From: Michael Chestnutt, Project Architect

Re: Remaining tree removal and replacement for the Luedke Residence

Crescent Ave., Great Diamond Island, Portland, ME 04109

E EXISTING SITE / TREE CLEARING DIAGRAM SCALE: 1" = 30'

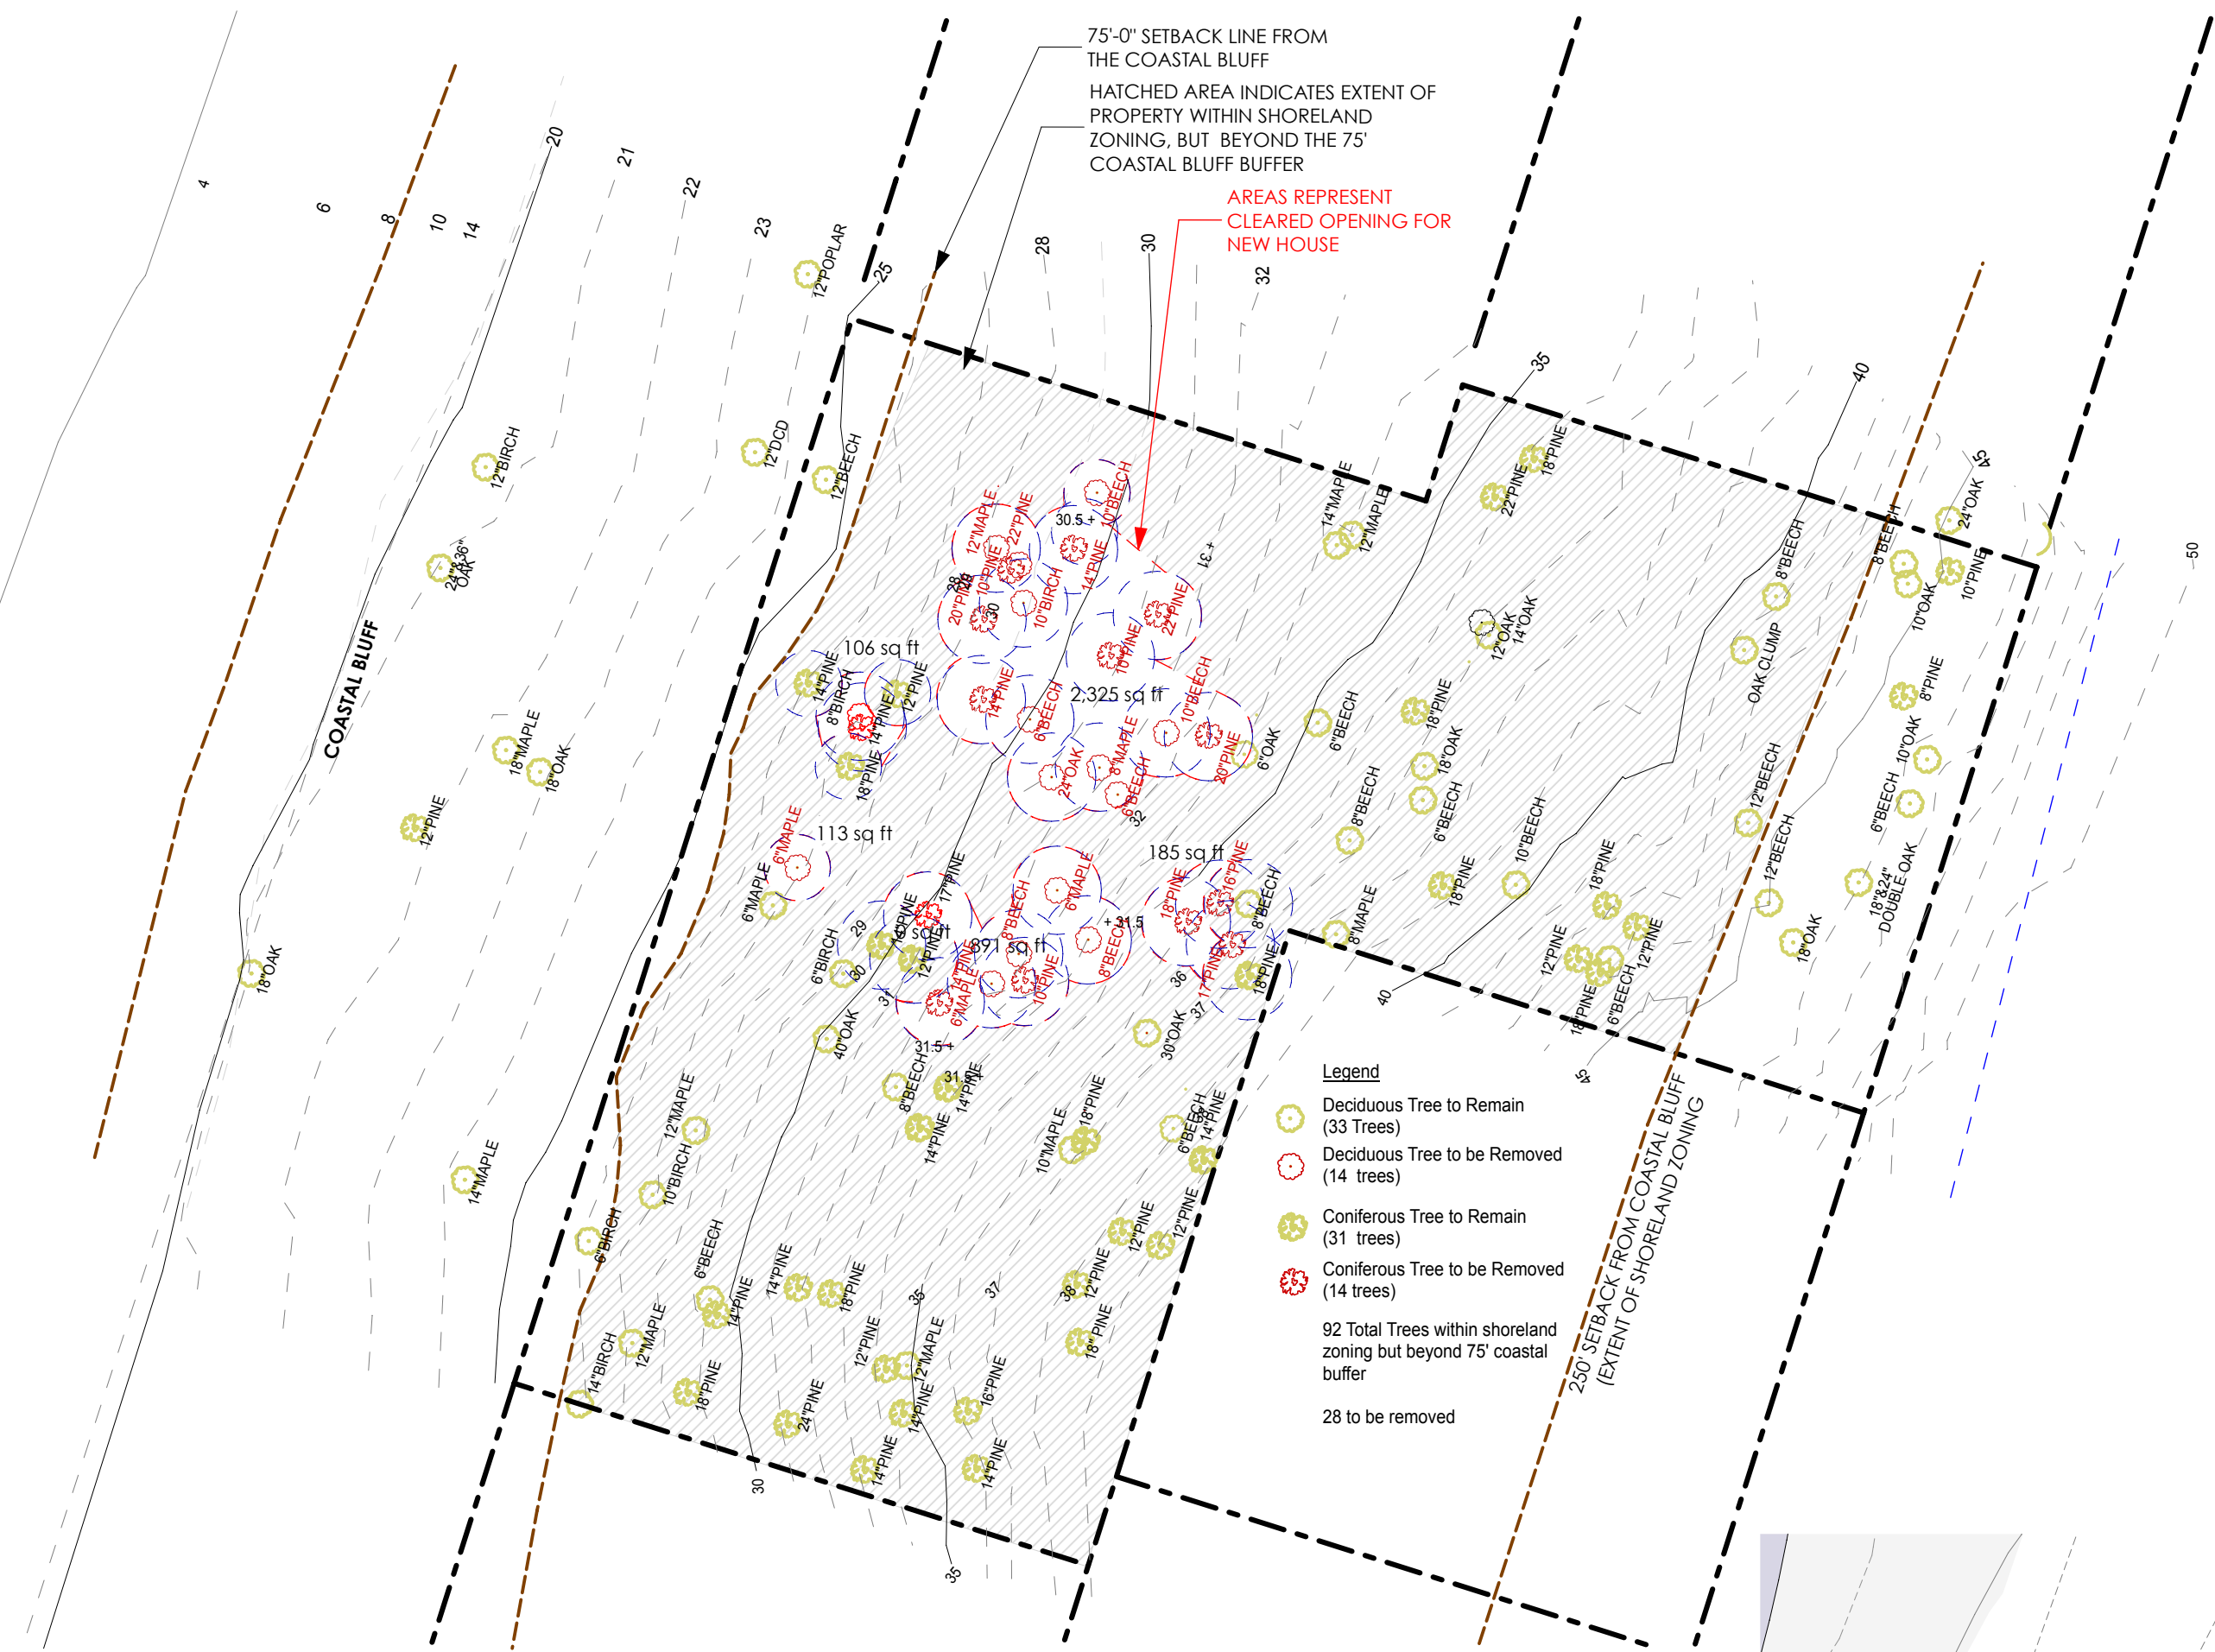
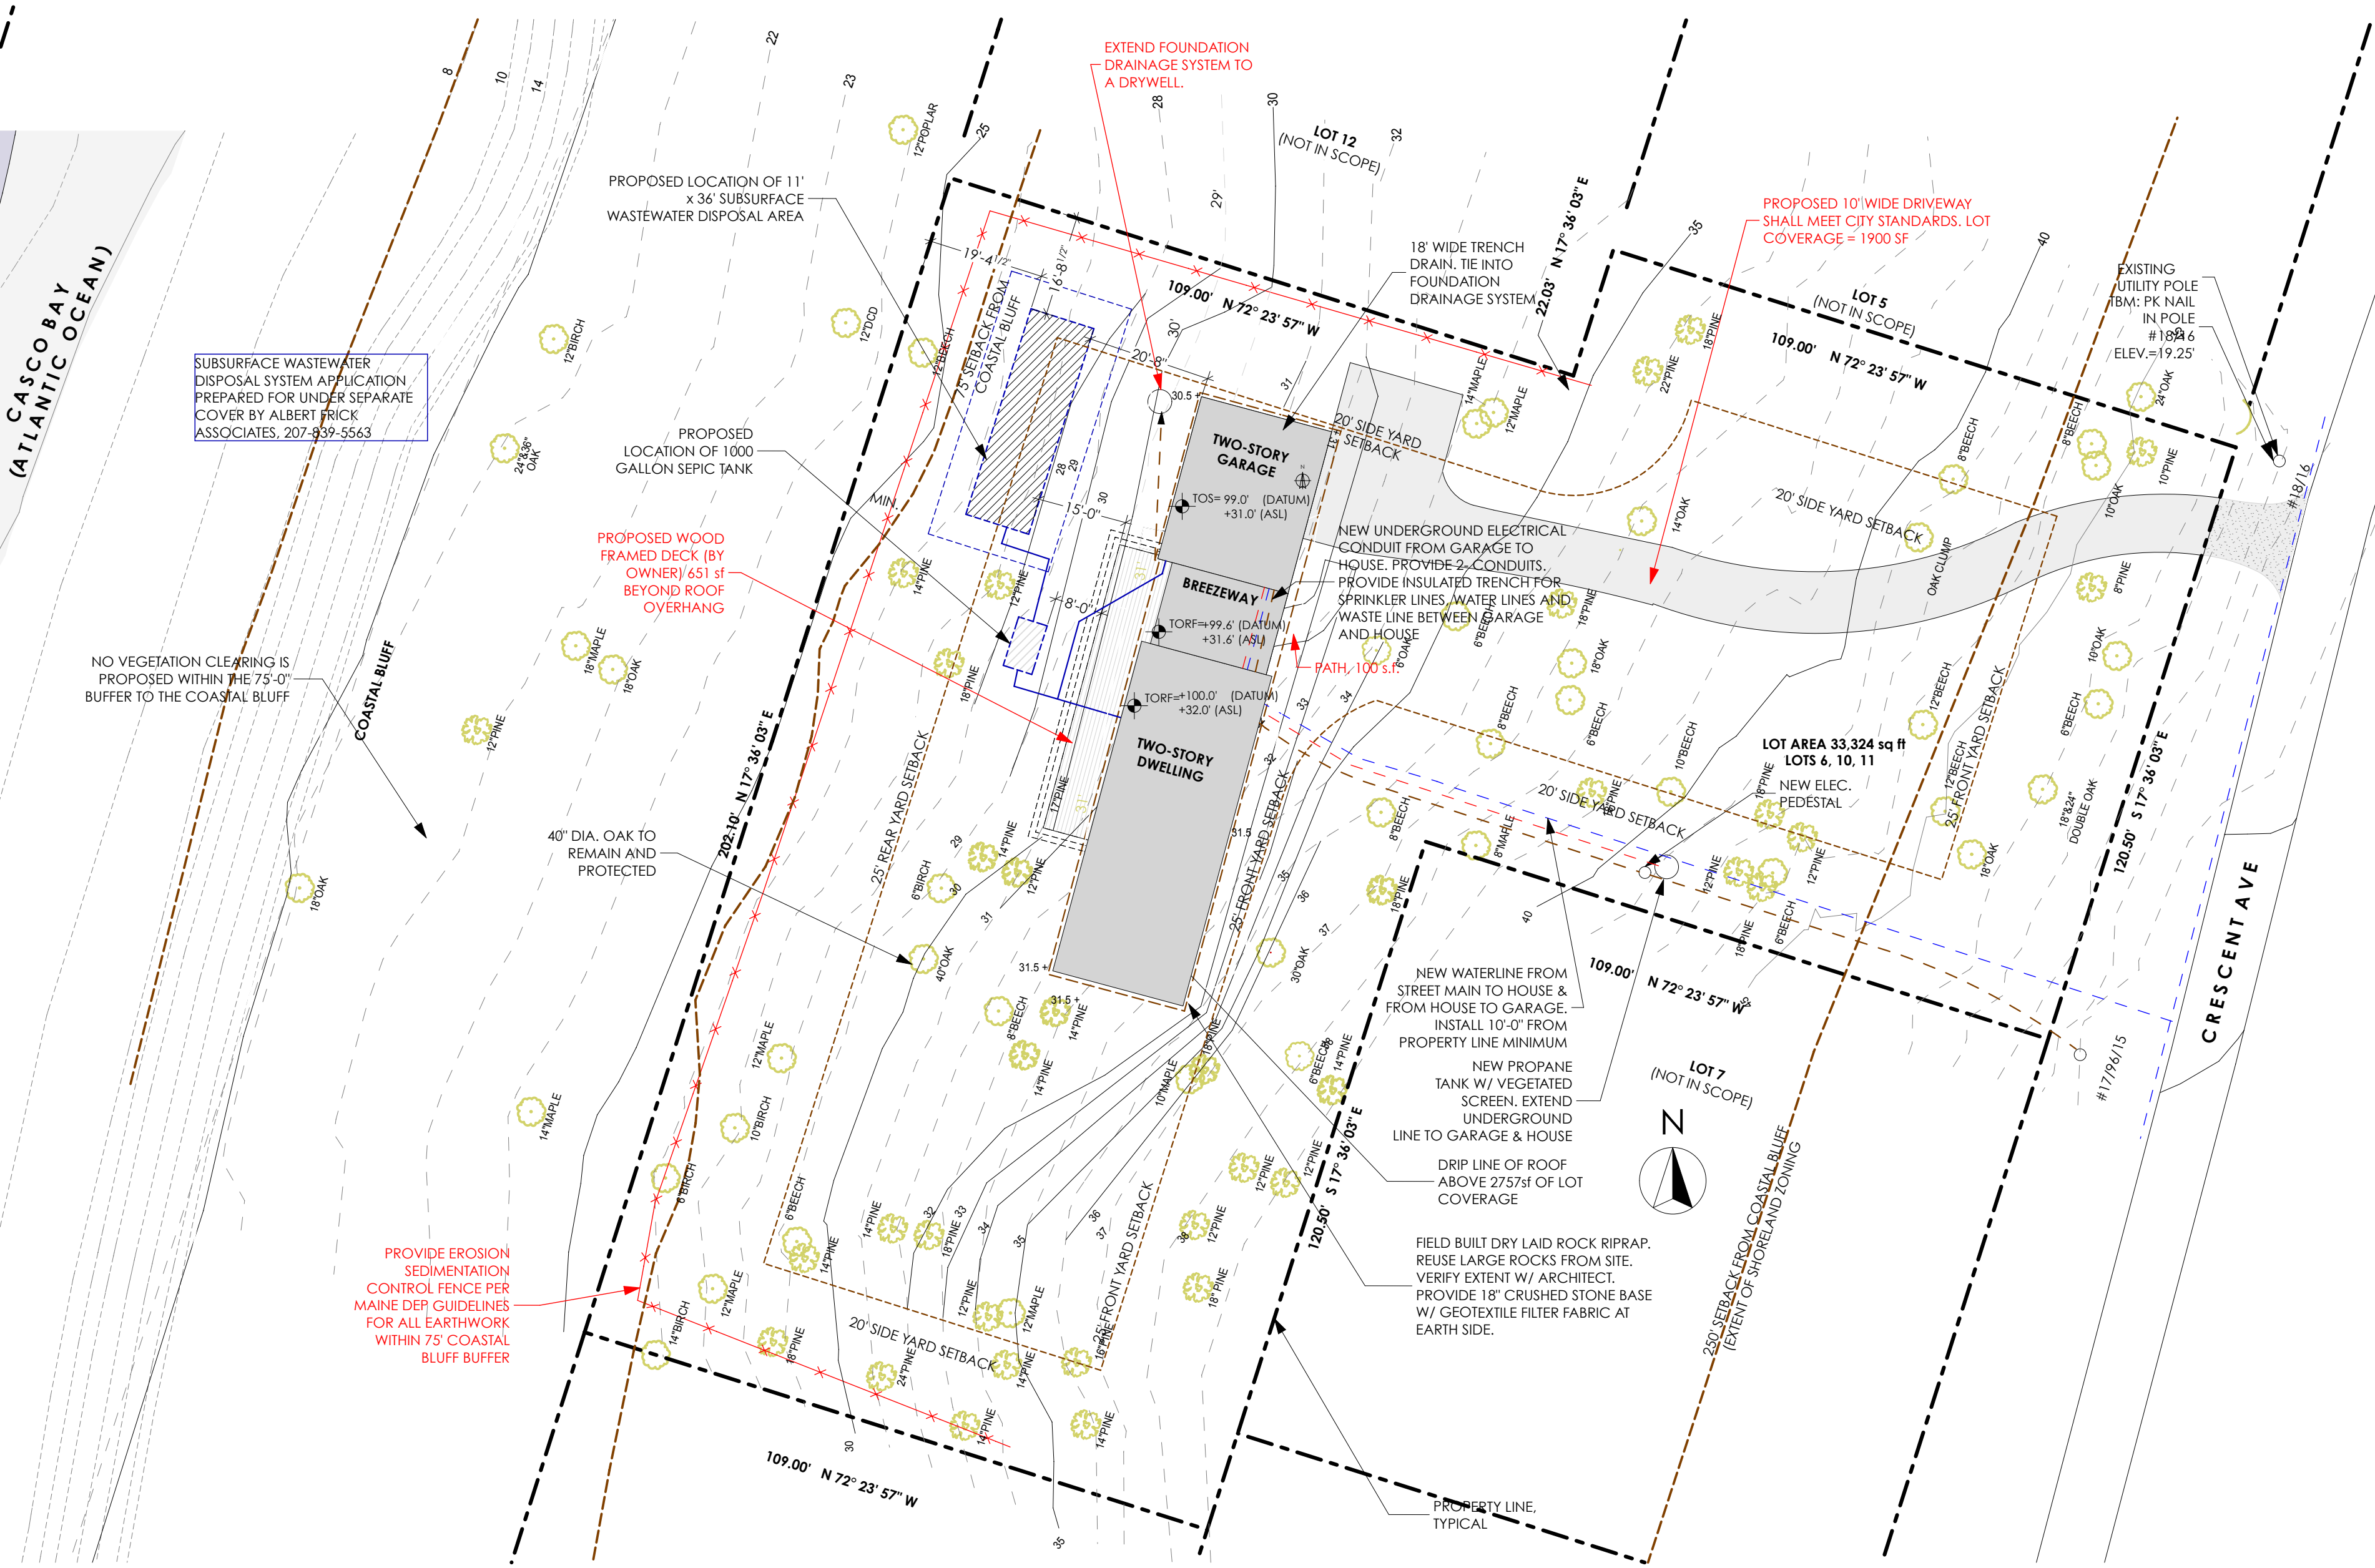
The following are a list of remaining tree removals and replacement trees for the above-mentioned project:

- ~~1. Lower West side (waterside) of residence: Remove 1 12" dia. Pine and 1 14" dia. Pine. Replace with 1 Birch (2" caliper) and 1 Native Maple (2" caliper)~~
- ~~2. Lower East side (road side) of residence: Remove 1 30" Oak (Tree is leaning toward future house). Replace with 1 Oak (2" caliper).~~
- ~~3. Upper East side (road side) of residence: Remove 1 18" Pine. Replace with 1 Birch (2" caliper).~~
4. South Side of residence: Remove 3- scotch pines (1-21" dia. and 2- 16" dia.). Replace with 3- 2" caliper White Pines and 3- 2" caliper Yellow Birch

Note: New tree locations shall be verified in the field with the Owner or Owners' representative.
